Recommendation Report for Planning Permission for Works or Extension to a Dwelling

REF NO: EP/108/19/HH

LOCATION: Caprice
17 Tamarisk Way
East Preston
BN16 2TF

PROPOSAL: Two storey front, two storey side and two storey rear extension and additional parking bay to garage

Elevations
as Proposed

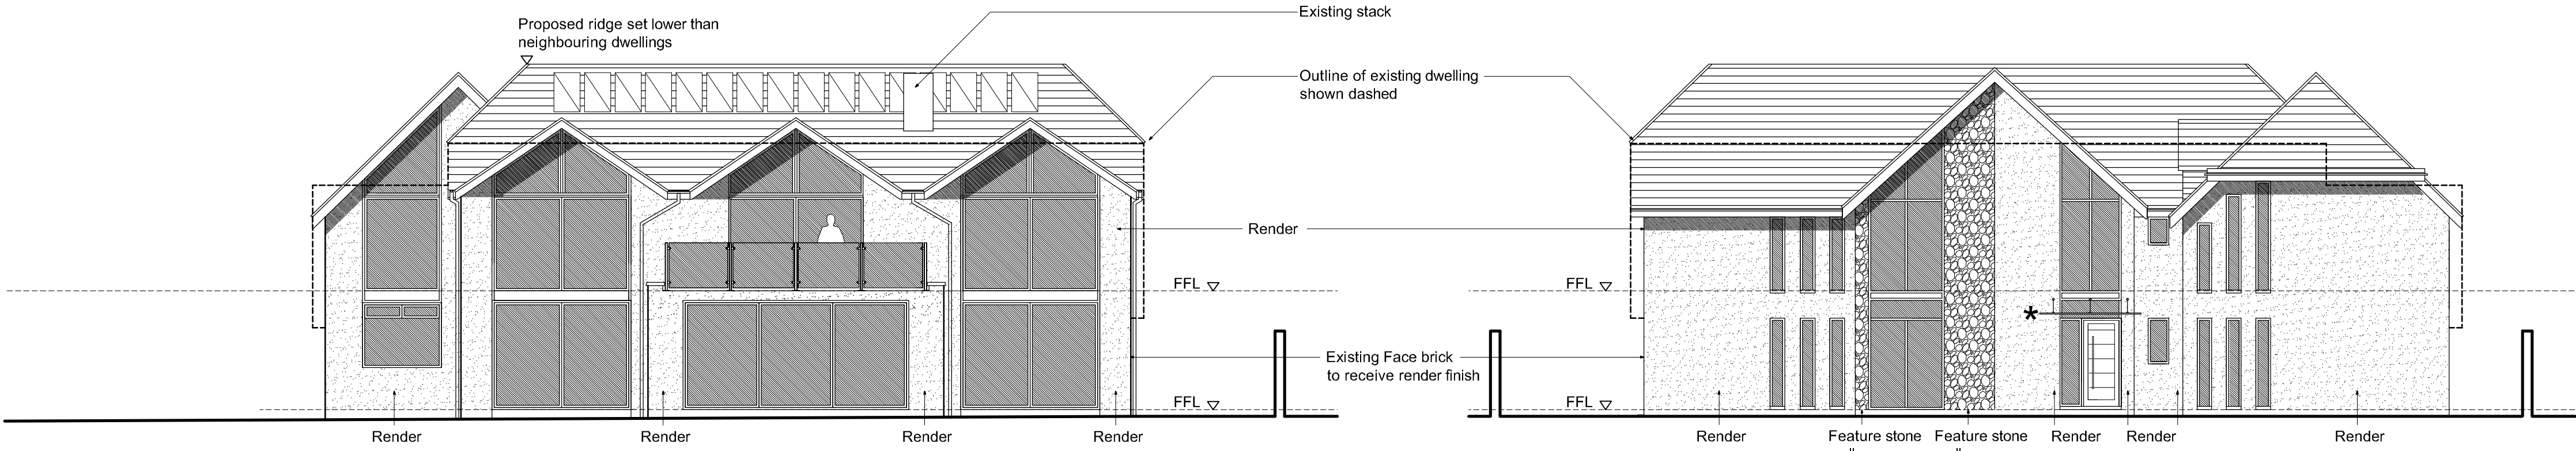
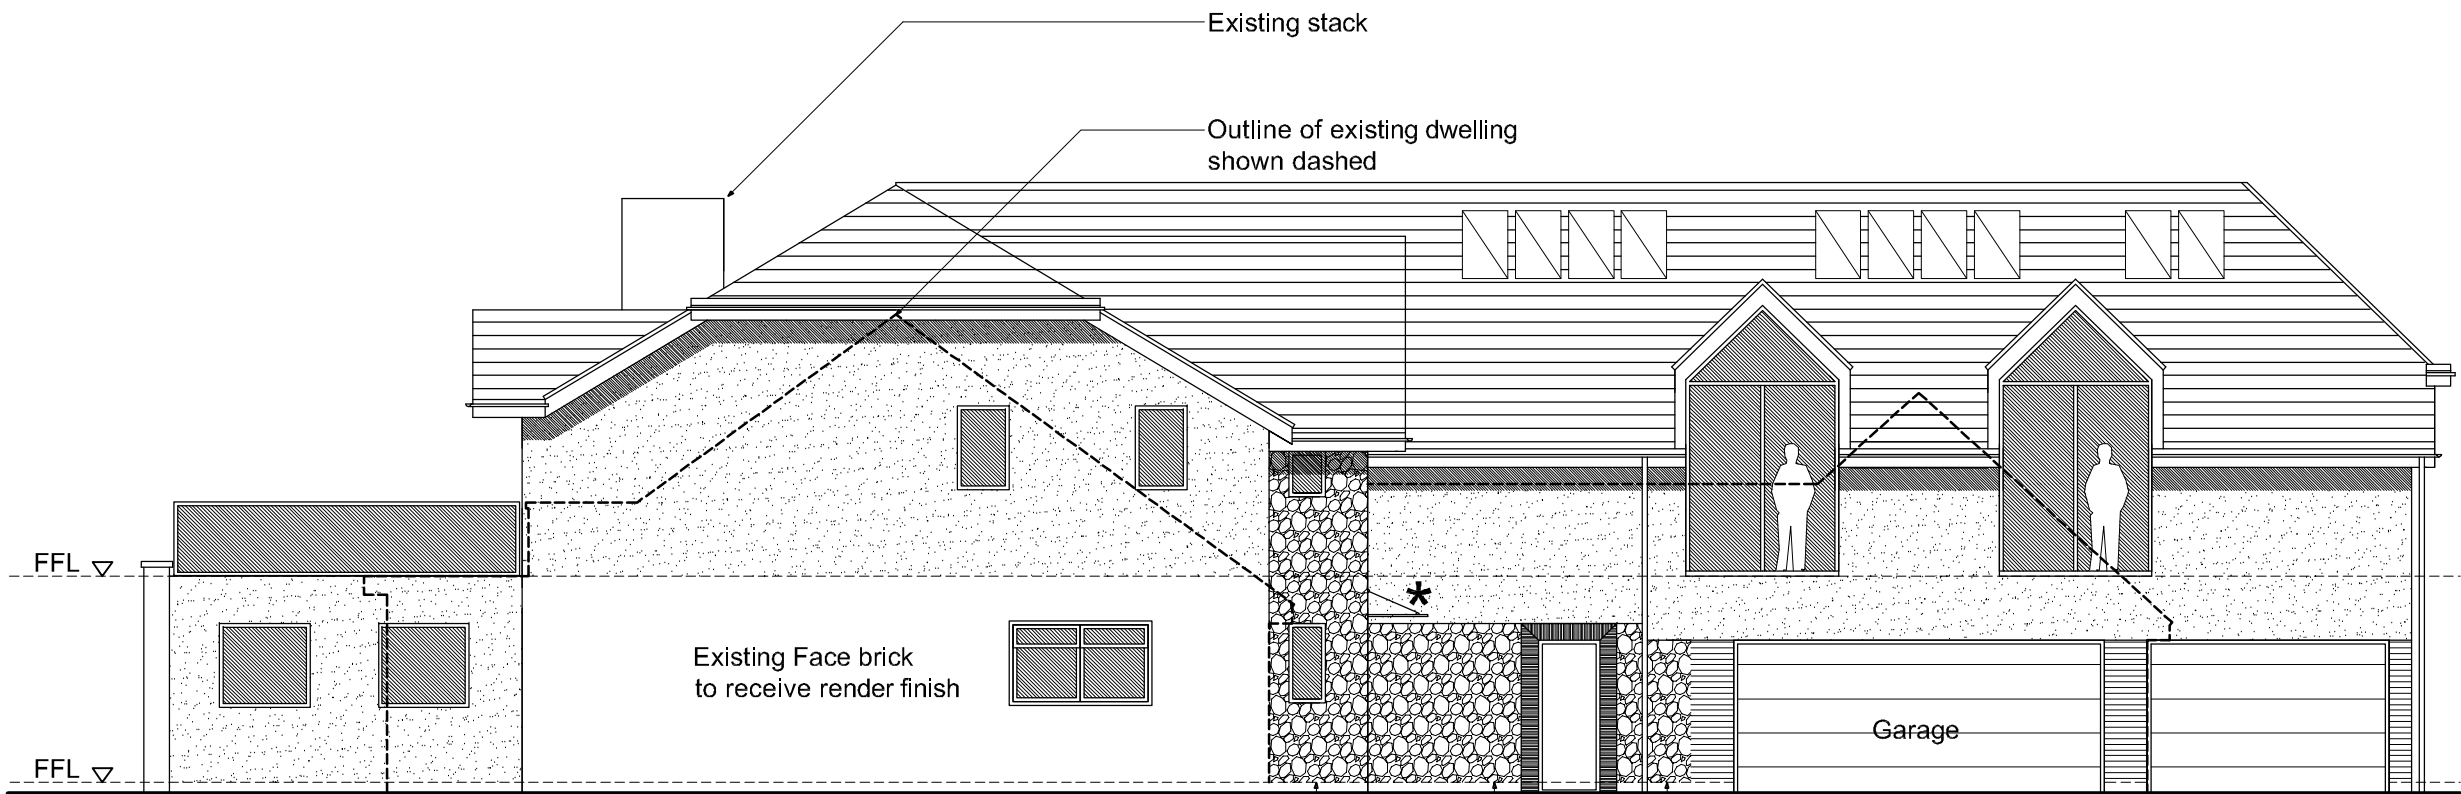
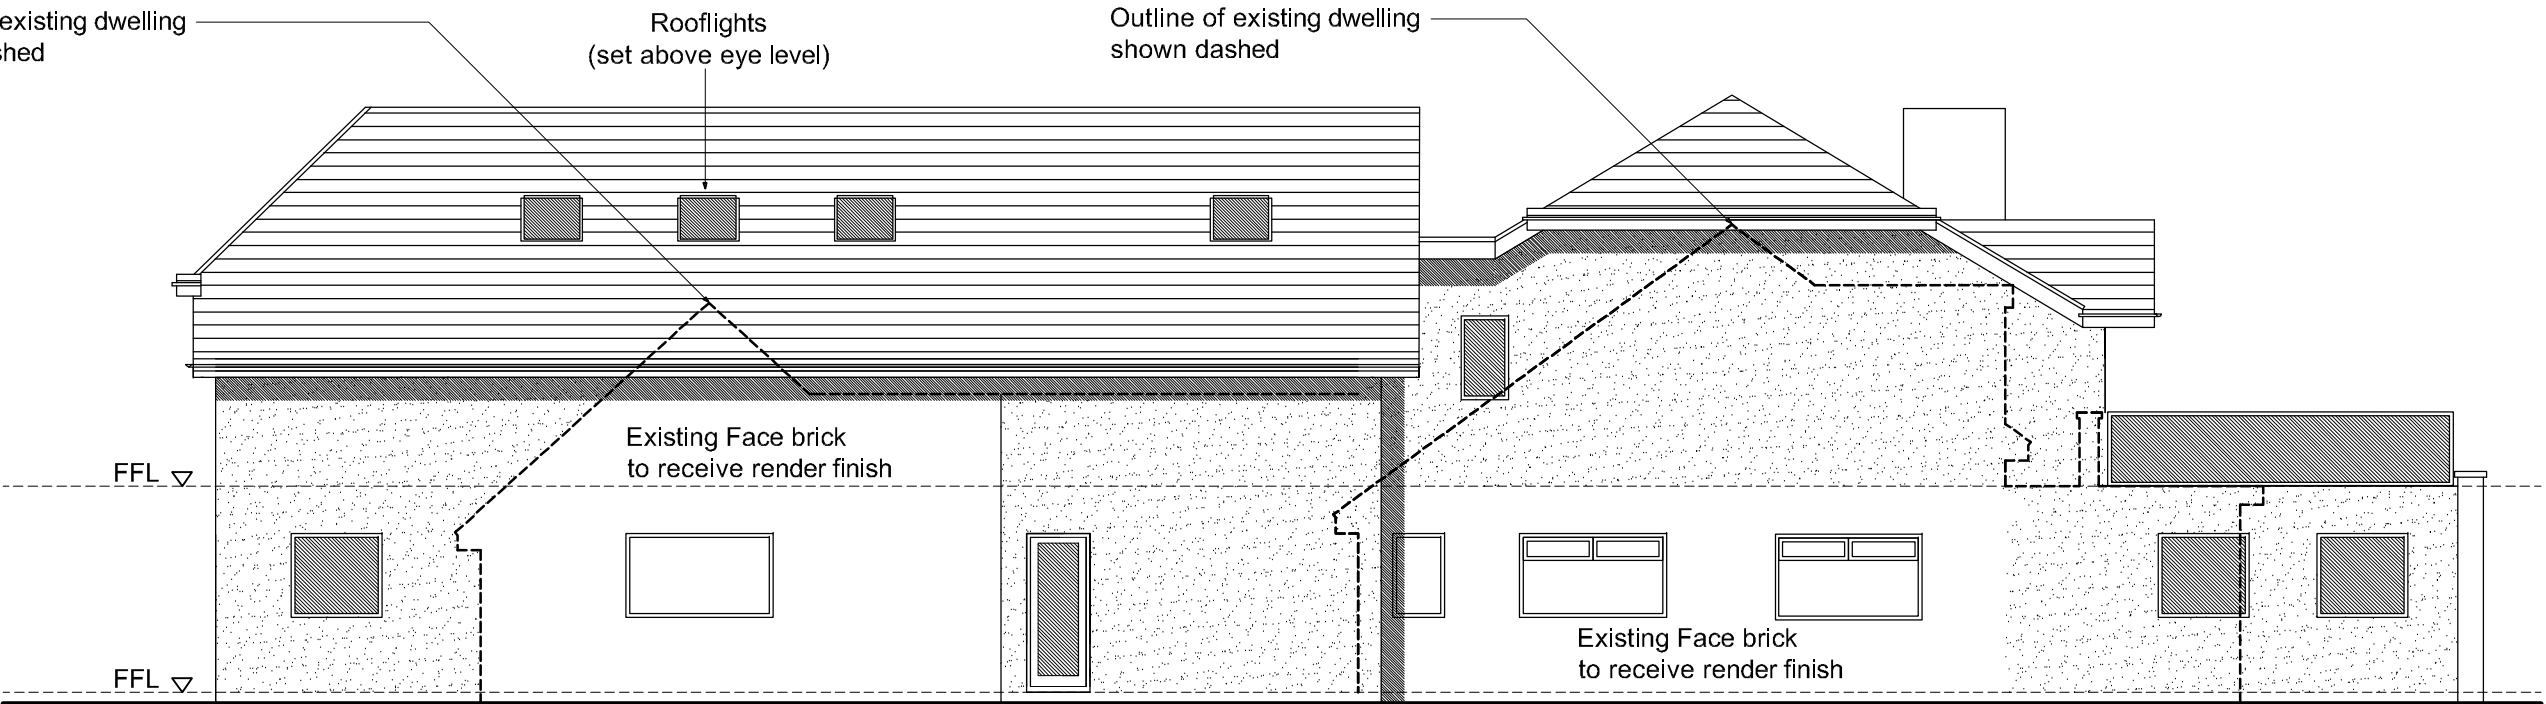
The proposed development is considered to result in a change of appearance of the host dwelling, as a result its scale, but it is not considered to have a significantly detrimental impact on the established character of the locality, as a result of its design and use of materials. The proposed materials are not considered to be uncommon within the area, with many examples of rendered dwellings found along Tamarisk Way. The proposed two storey side extension is readily visible from the street scene, as a result of its siting and scale, and the fact that in conjunction with the rest of the proposed development it involves the addition of a full first floor, to what is currently a chalet bungalow. Therefore, resultant of its relationship with the host dwelling in terms of scale and design, it is not considered to be a subservient addition to the host dwelling. The area is not considered to have a uniform spatial pattern, as a result of the inconsistent roof shapes that appear in this locality, it is noted that the proposed development is lower in maximum height than the neighbouring dwelling to the East, and West.

The Northern (front) element of the proposal, due to its siting, is visible from the street scene. Whilst the proposal is considered to comprise a change to the appearance of the host dwelling, it is not considered to have a harmful impact on the character of the host dwelling. Due to its configuration, the proposed front extension does not extend beyond the proposed Northernmost projection of the host dwelling (part

of the side garage). Resultant of this, and its scale and design, the proposed development is considered to appear well integrated with, and subservient to the host dwelling. This is considered to allow this element of the proposal to have no significantly harmful impact upon the character of the locality, or the host dwelling.

The application includes the provision for a first floor terrace to the rear of the host dwelling, which projects approximately 5m from the rear of the host dwelling, and as such, provides views to the South, East and West. The site at current is bordered by mature foliage that screens the views from the current roof balcony, however, there is nothing to prevent the removal of this foliage, in that there is no relevant Tree Preservation Order at the site. To the East, it is considered that there would be direct overlooking of the conservatory, and patio area of the adjacent dwelling, which would result in unacceptable overlooking, however, a condition will be imposed ensuring that an opaque screen be installed along the Eastern aspect of this balcony, in order to prevent said view. To the West, the proposal is not considered to give rise to any unacceptable overbearing, due to the views available being only those of the roof of the neighbouring dwelling. To the South, the available views are contained within the application site. It is noted that there are windows on the side elevations of the proposed development, however, there are no openings that are considered to give rise to any significant overlooking of adjacent dwellings.

- Location & Block Plan - 17-111.1-Loc
 - Proposed Floor Plans - 17-111.104
 - Proposed Elevations - 17-111.107
 - Proposed Street Scene - 17-111.108
Reason: For the avoidance of doubt and in the interests of amenity and the environment in accordance with policy D DM1 of the Arun Local Plan.
- 3 The Eastern elevation of the proposed roof terrace shall at all times be obscured to a height of 1.7m with fixed obscured glass and said screening shall be retained in perpetuity.

Street-scenes
as Proposed

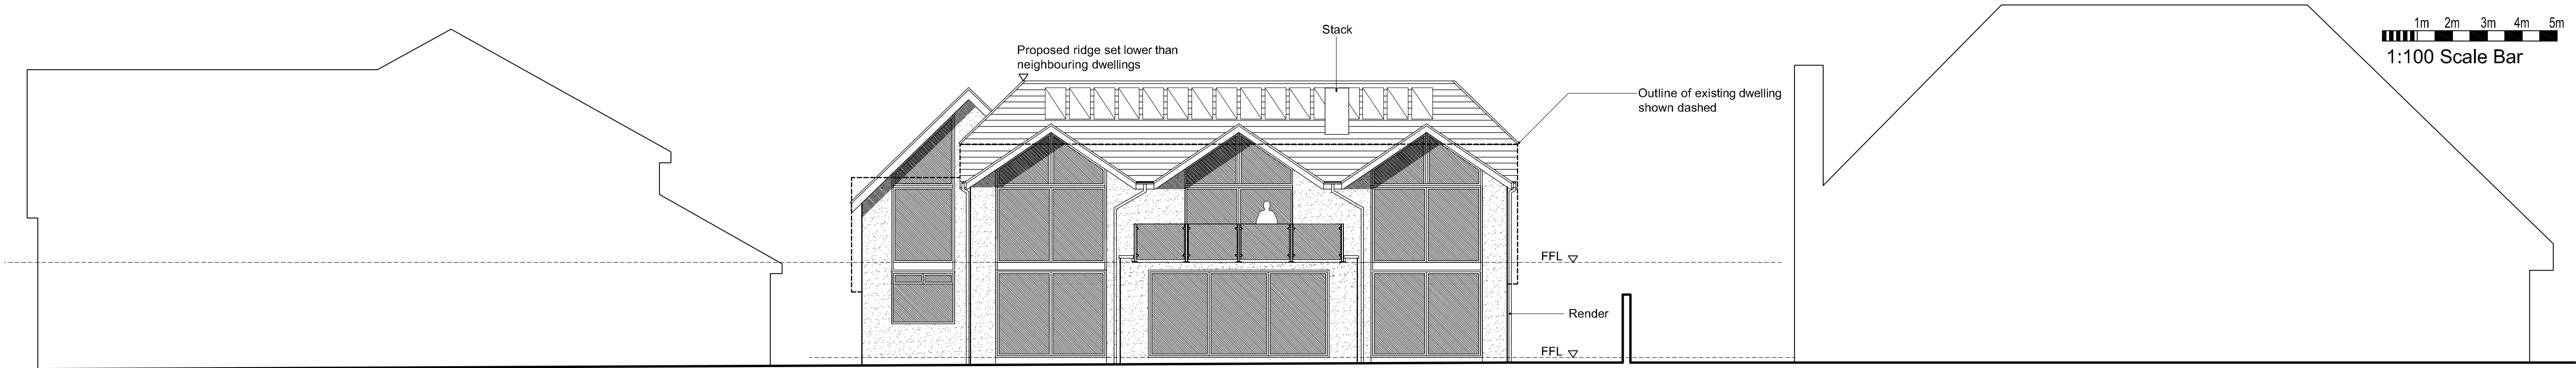
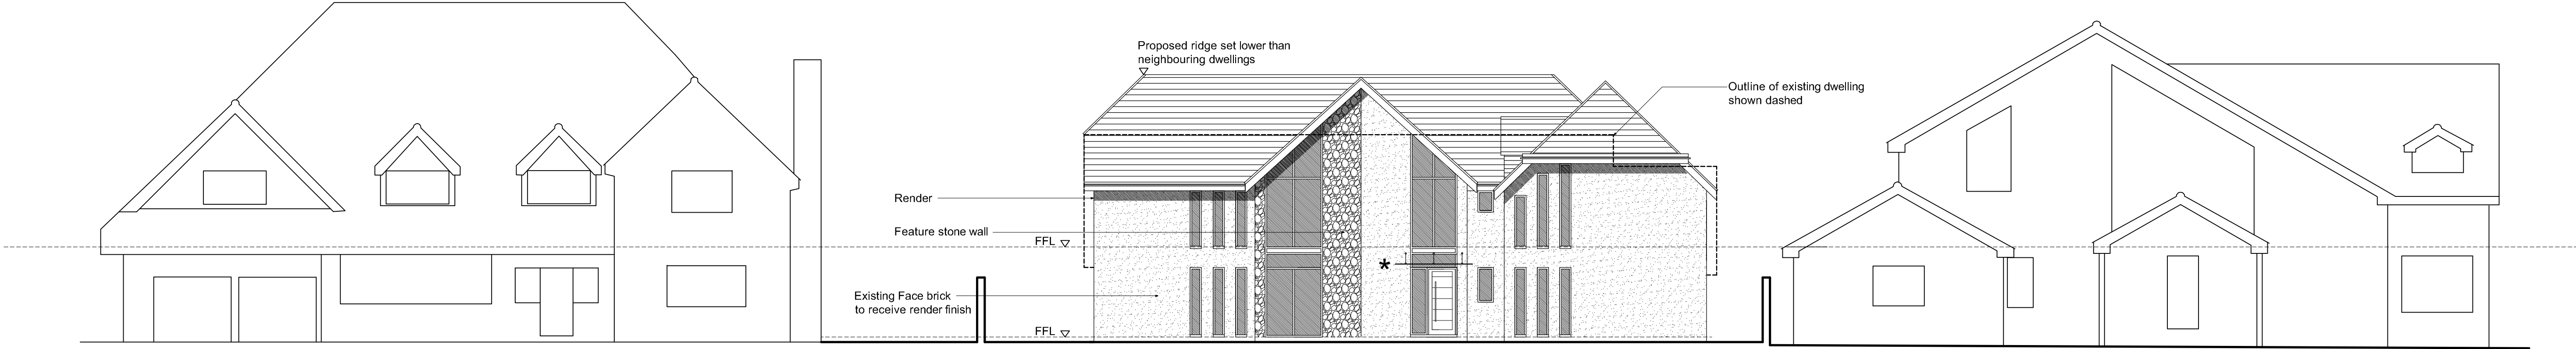
The application seeks to remodel and modernise the host dwelling, by way of various alterations. The locality is host to a wide variety of dwelling designs and types, and therefore has a mixed character. This is especially evident when at the application site, in that the dwelling to the East is constructed of traditional materials, then to the West, a more modern, contemporary dwelling.
